PROFILE - SEGMENT 8a

THIS DRAWING IS THE PROPERTY OF GMS, INC. NO REUSE, REPRODUCTION, MODIFICATION OR EXTENSION OF THIS PROJECT DESIGN OR ANY PART THEREOF IS TO BE MADE WITHOUT THE WRITTEN CONSENT OF GMS, INC.	
DESIGNED BY: KW CHECKED BY: EM DATE: 01/09/2017 PROJECT NO.: 15061300 DWS FILE NO.: 2810	GMS, INC. CONSULTING ENGINEERS 611 S. WEBER, SUITE 200 COLORED SPRINGS, COLORADO 80903
SEGMENT 8a AND DETAIL WATER SYSTEM IMPROVEMENTS CASCADE METRO-POLITAN DISTRICT NO. 1	
SHEET 12 OF 30

SEGMENTS 3c AND 7b
 WATER SYSTEM IMPROVEMENTS
 CASCADE METROPOLITAN DISTRICT NO. 1

A PROFILE - SEGMENT 8a  
 12 SCALE: 1" = 30' HORIZ., 1" = 5' VERT.

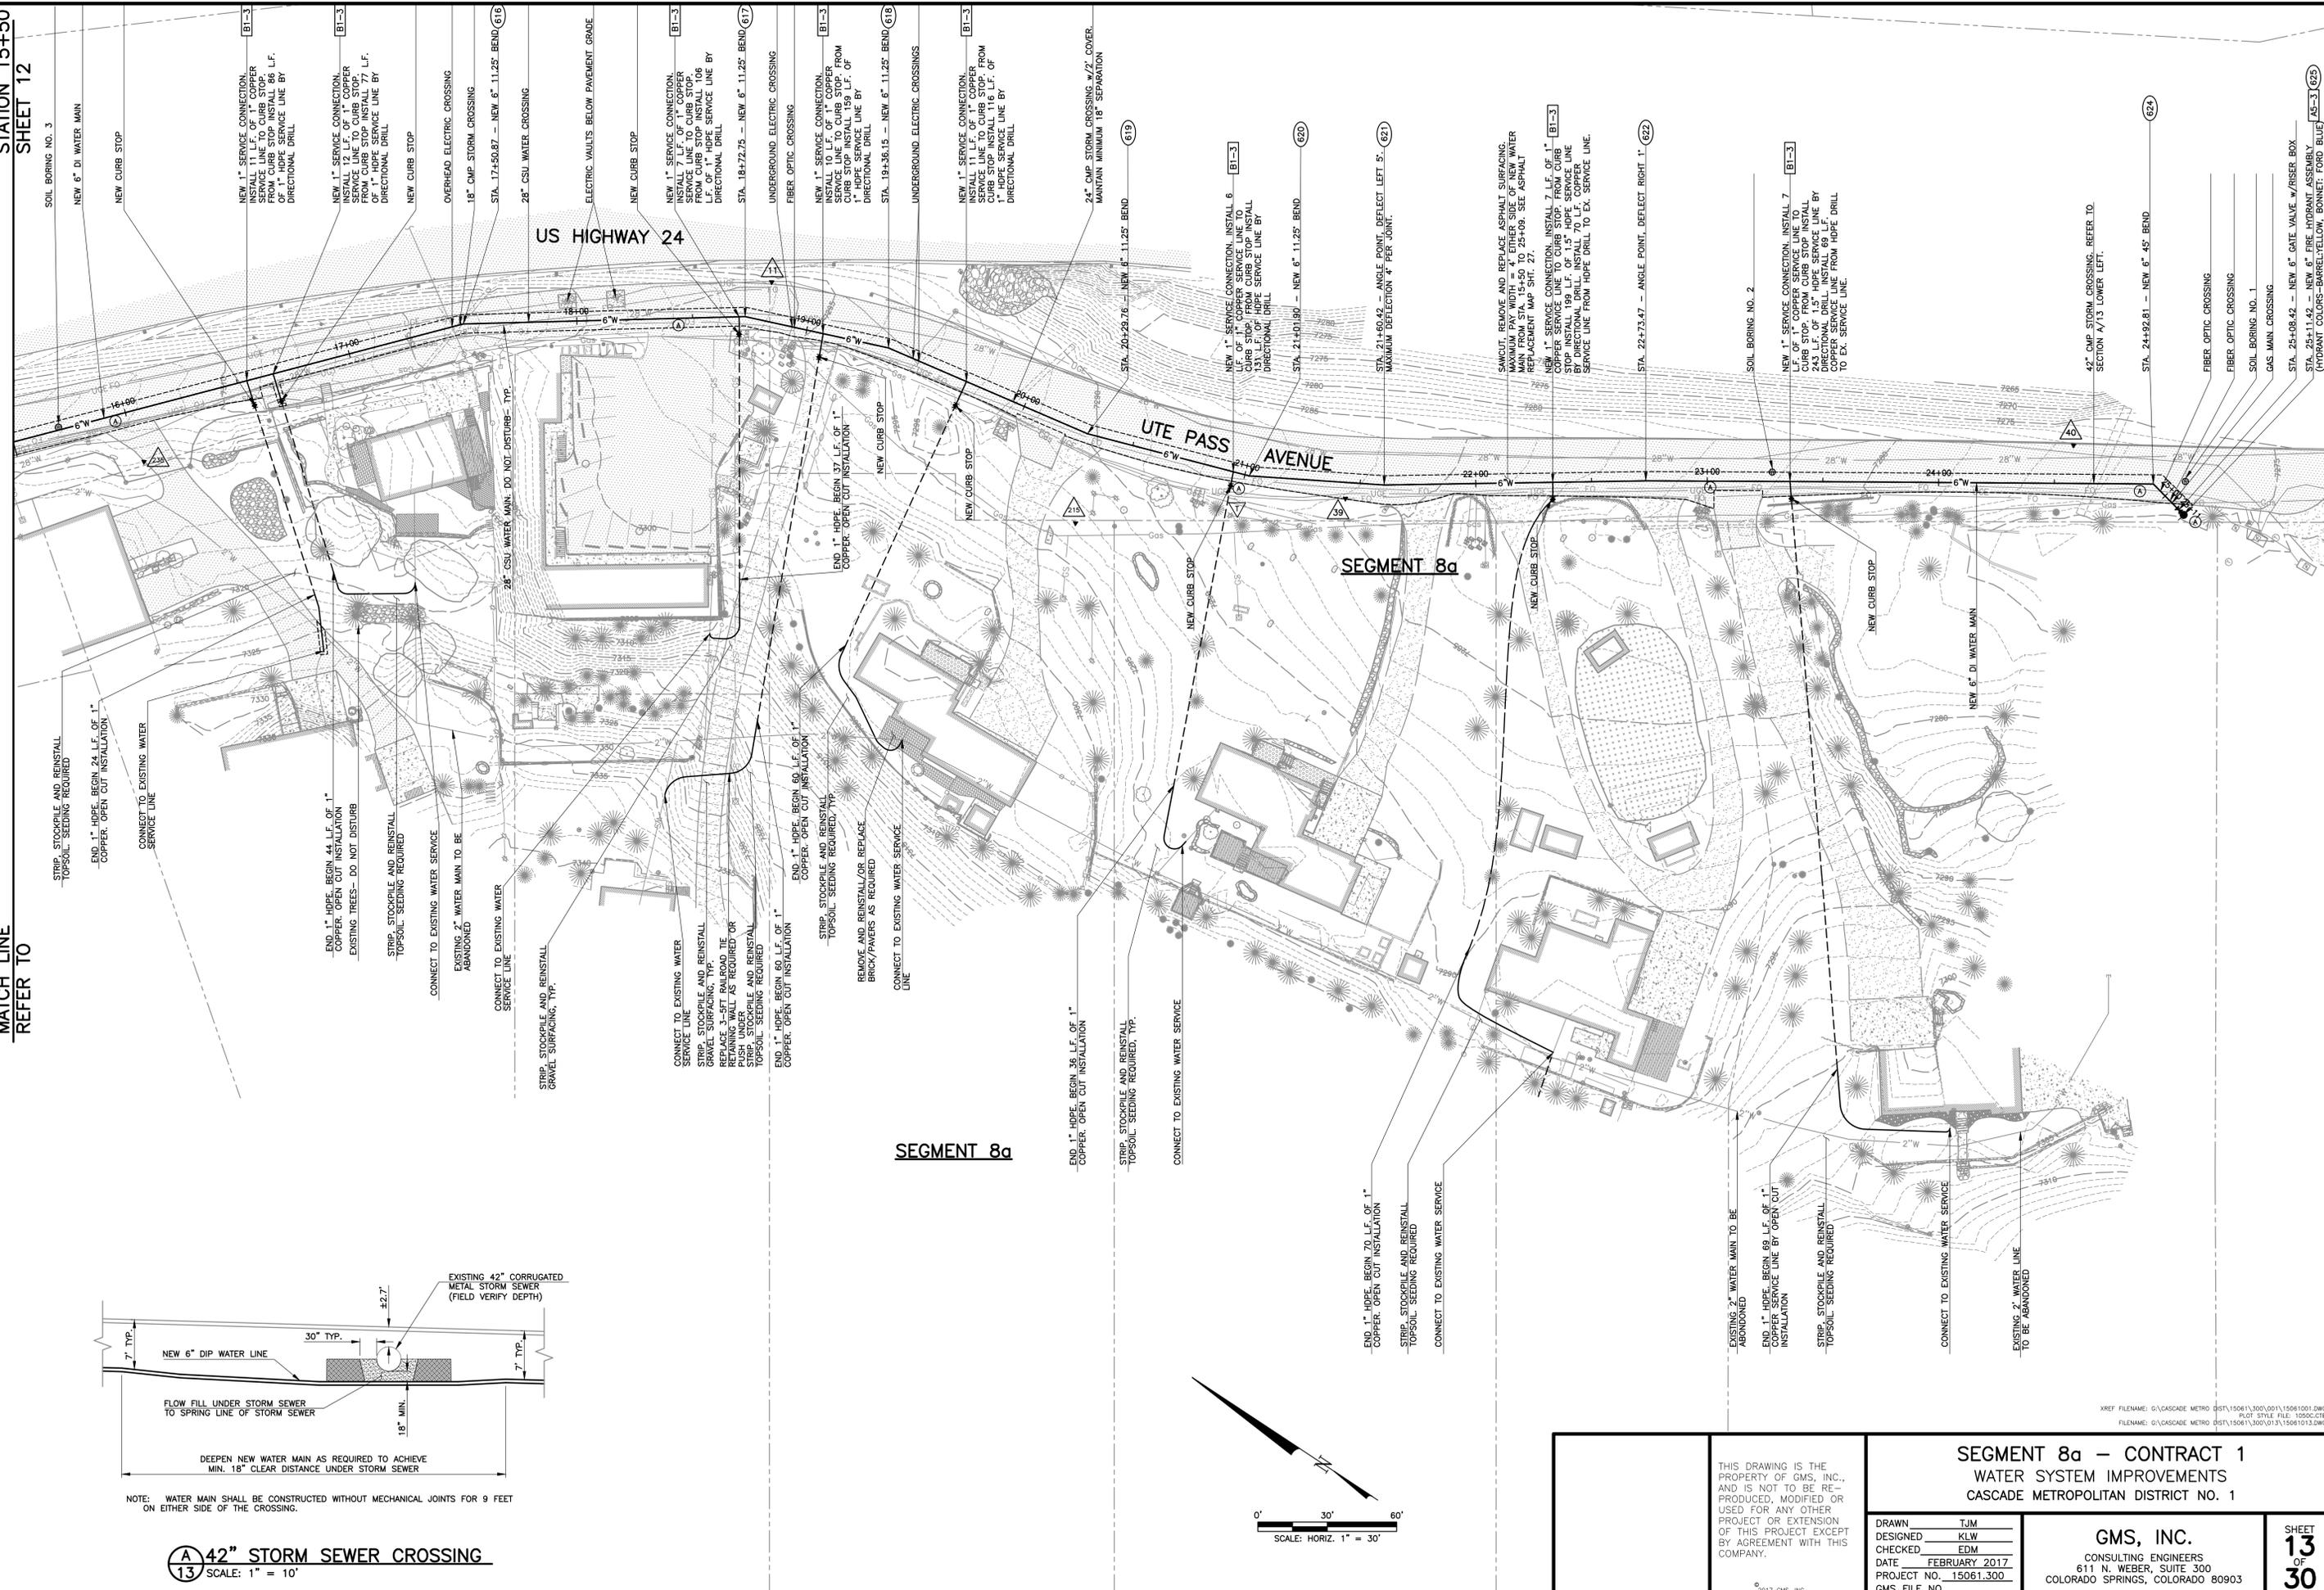
Address boring excavations and dewatering in GEC Plan and SWMP.

**SEGMENTS 3c AND 7b - CONTRACT 1**  
**WATER SYSTEM IMPROVEMENTS**  
**CASCADE METROPOLITAN DISTRICT NO. 1**

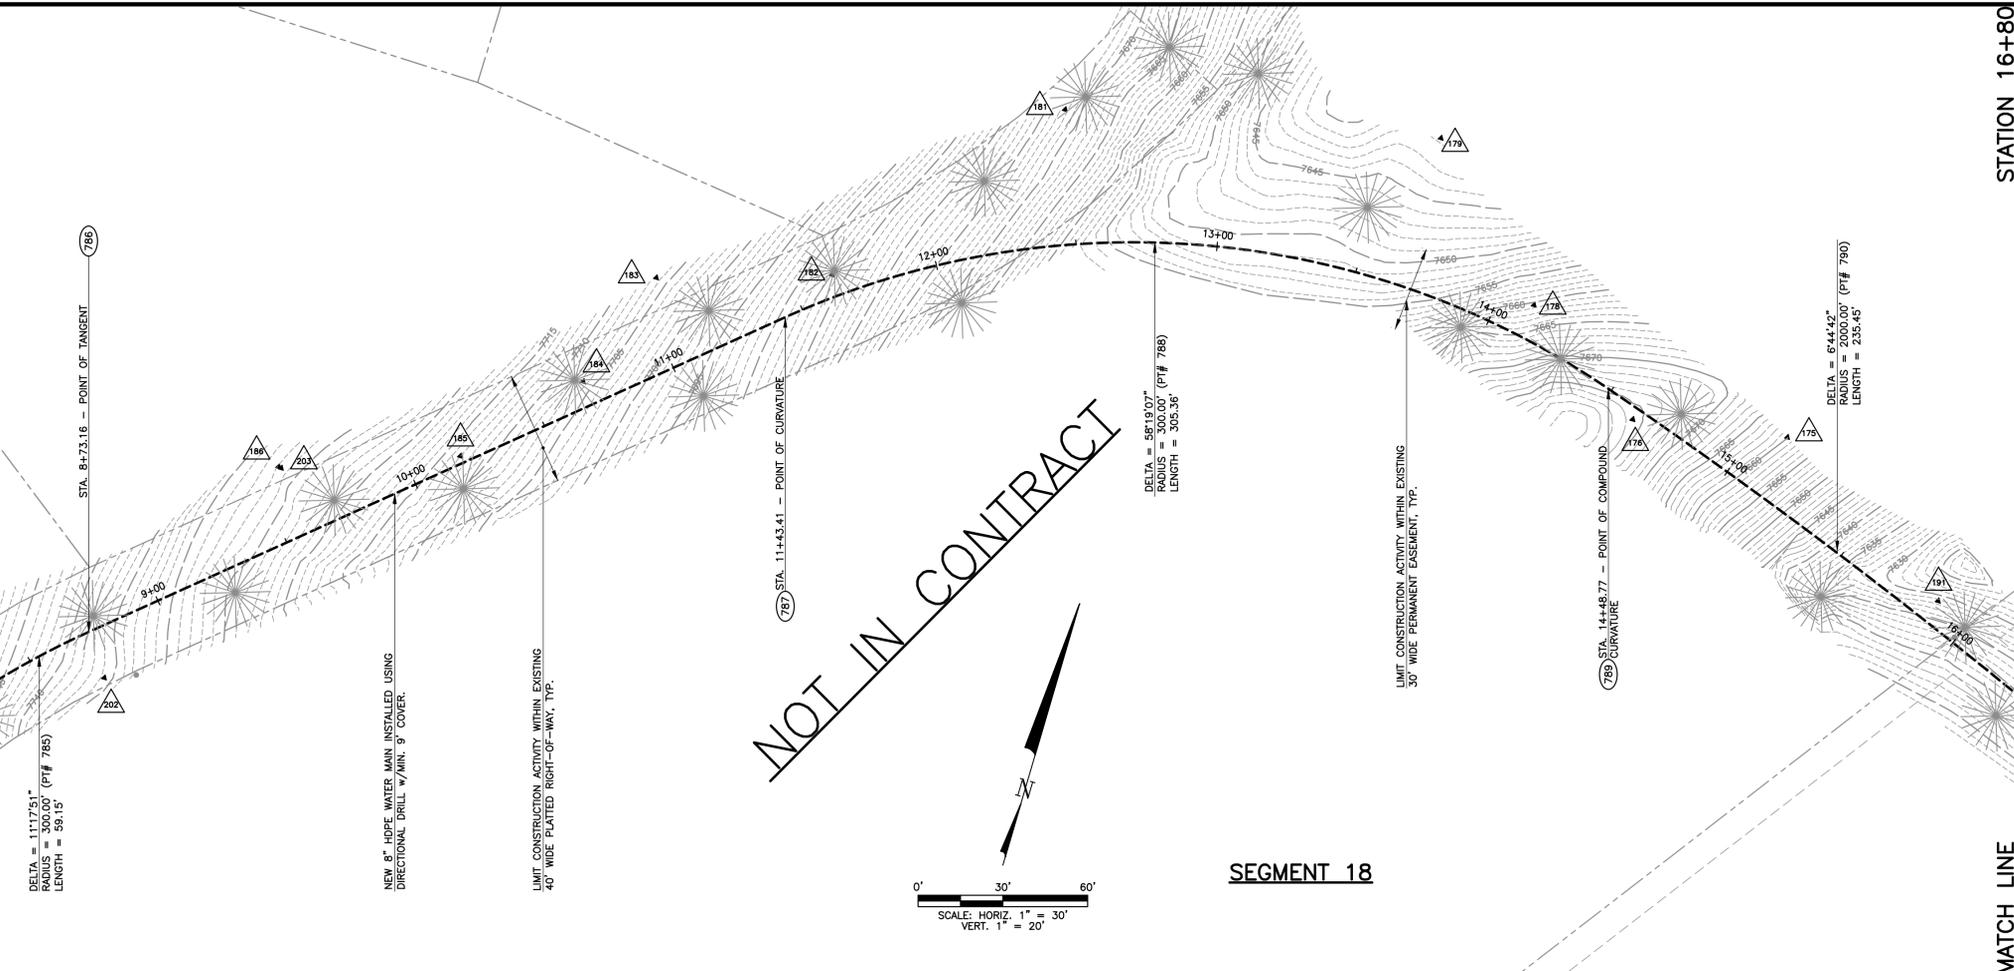
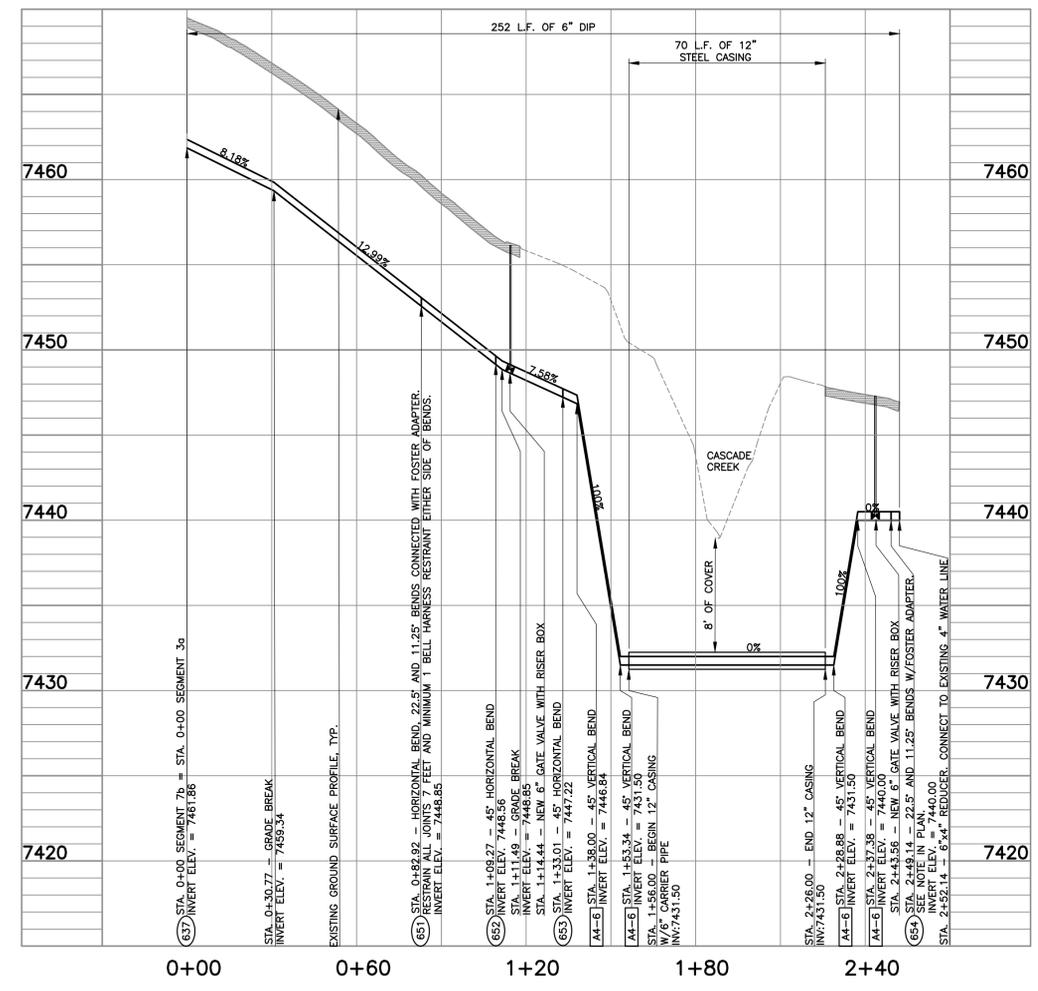
Is this also to be bored or open cut?
 Address in CEC plan and SAMP.
